599 Warren Ave.
Dunkin Donuts
Kinco Realty

**CITY OF PORTLAND, MAINE
DEVELOPMENT REVIEW APPLICATION
PLANNING DEPARTMENT PROCESSING FORM**

Dunkin Donuts Project Name/Description

From: Marge Schmuckal
To: Kandi Talbot
Date: 03/16/2005 4:28:56 PM
Subject: 597 Warren Ave - Dunkin' Donuts

FRONT ELEVATION (Parking Lot)
SCALE: 1/4" = 1'-0"

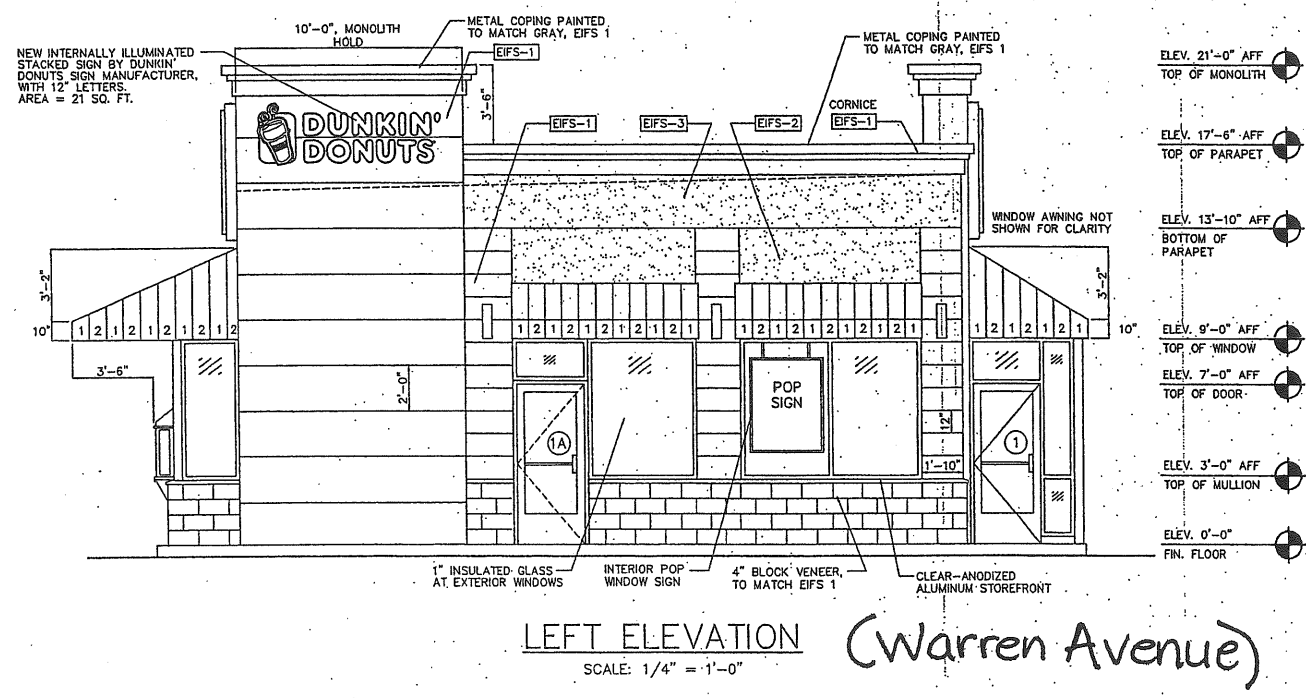
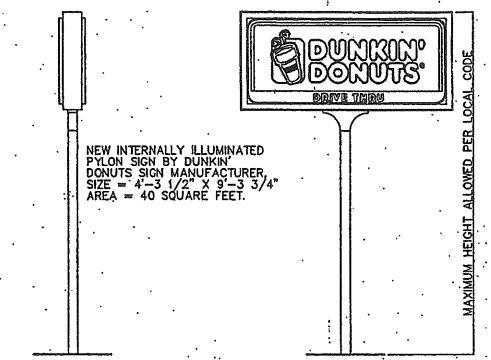
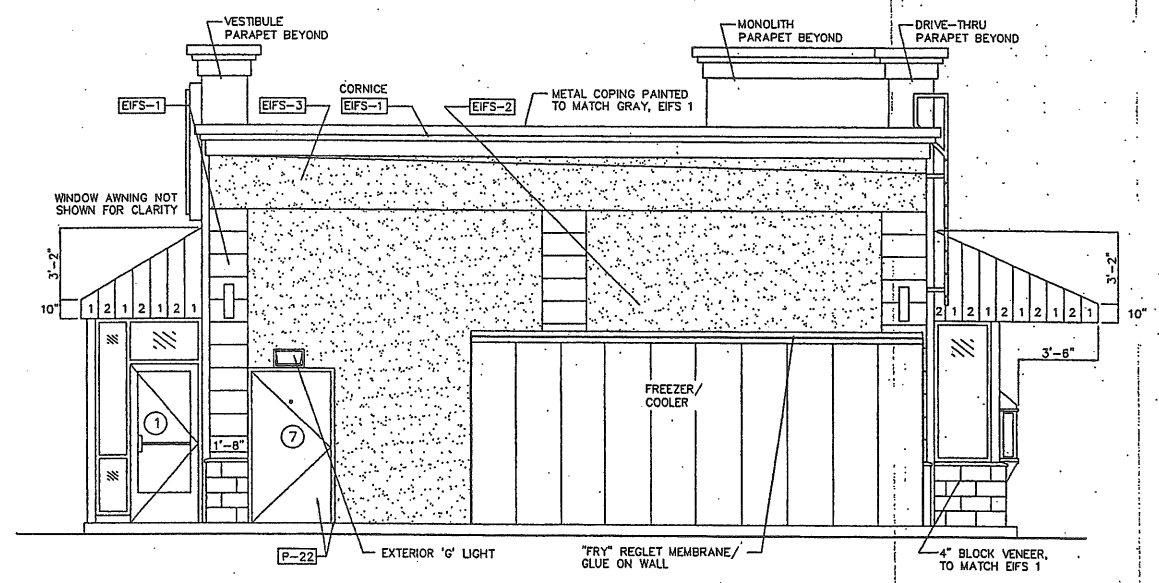
The B-4 zone only allows one sign per street frontage plus one extra or two signs. The building plans are showing three signs which is one sign over the allowable under the sign ordinance.

Existing Wendy's sign with proposed Dunkin' Donuts addition.

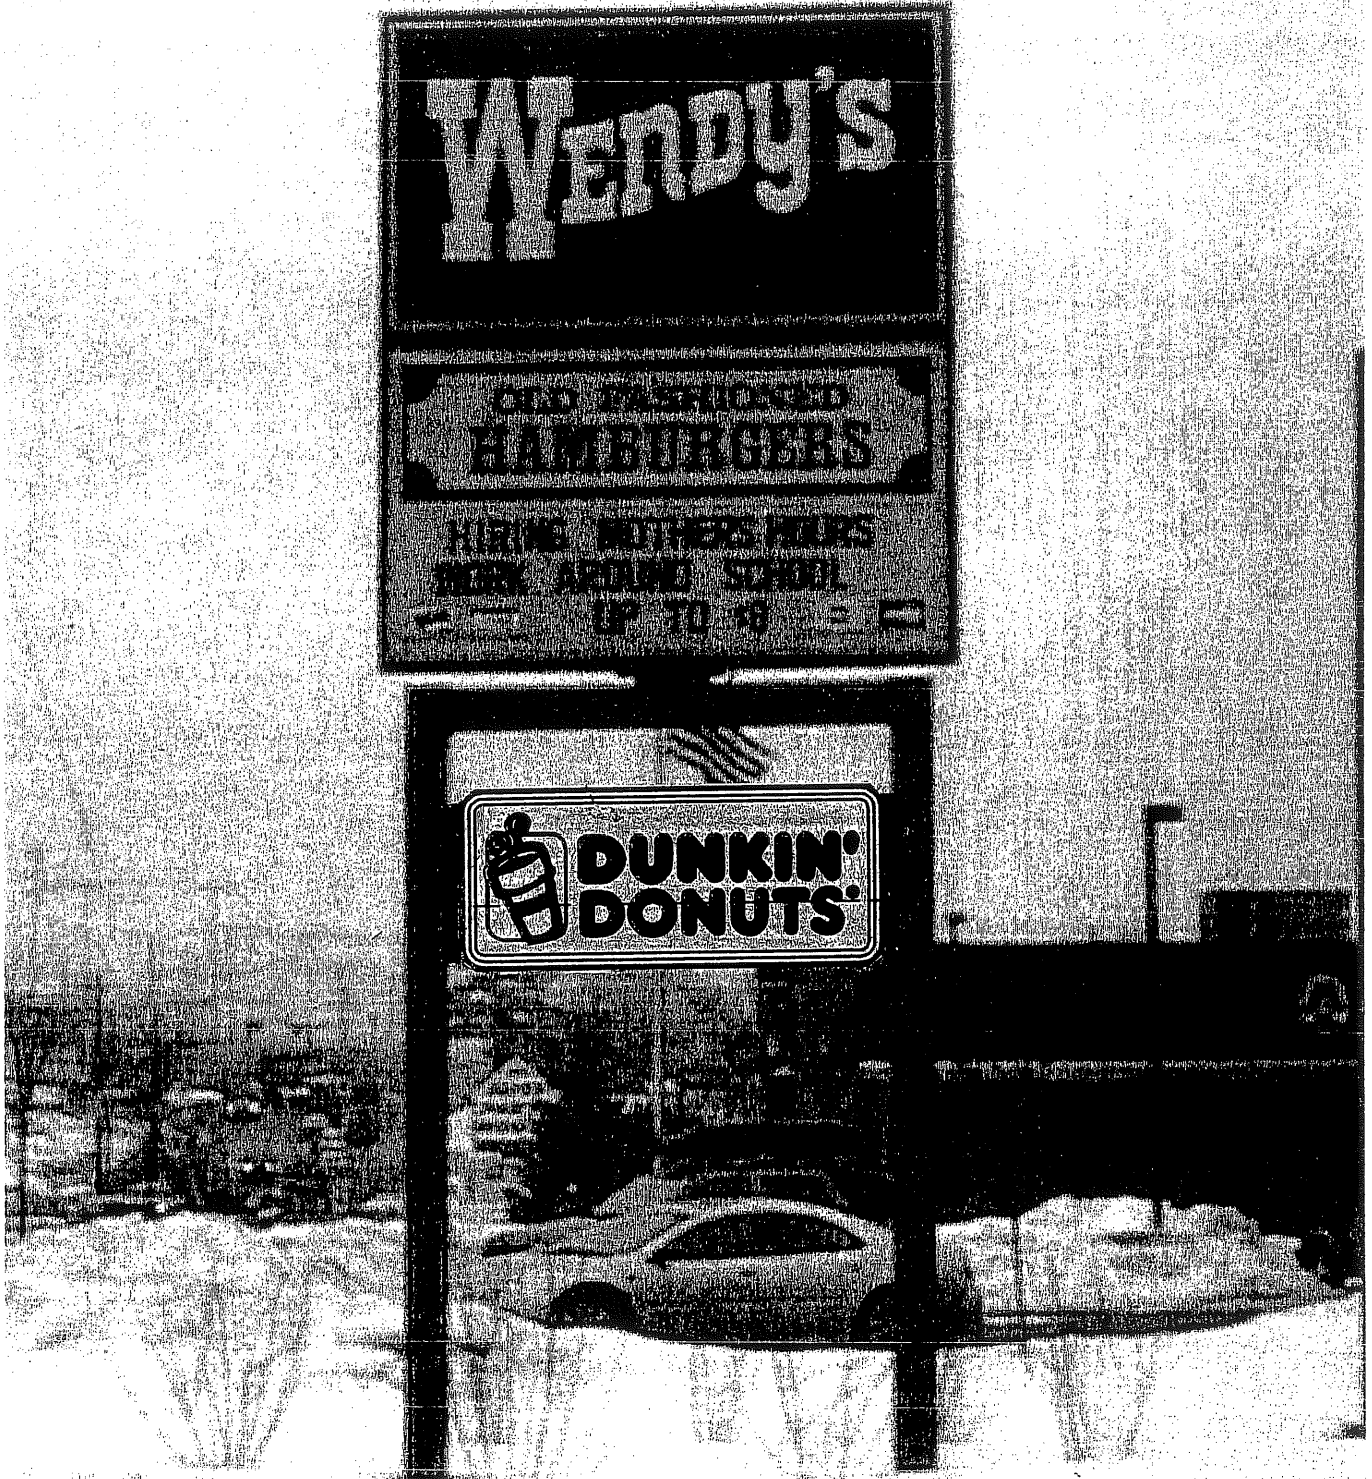
You also dropped off plans for signage on 3/16/05. They are not meeting the signage requirements. Currently they are showing an off premise pole sign. They are apparently proposing to share a sign with Wendy's. The City of Portland does not allow off premise signs. The proposed signage on that shared sign is just over the maximum of 65 square feet.
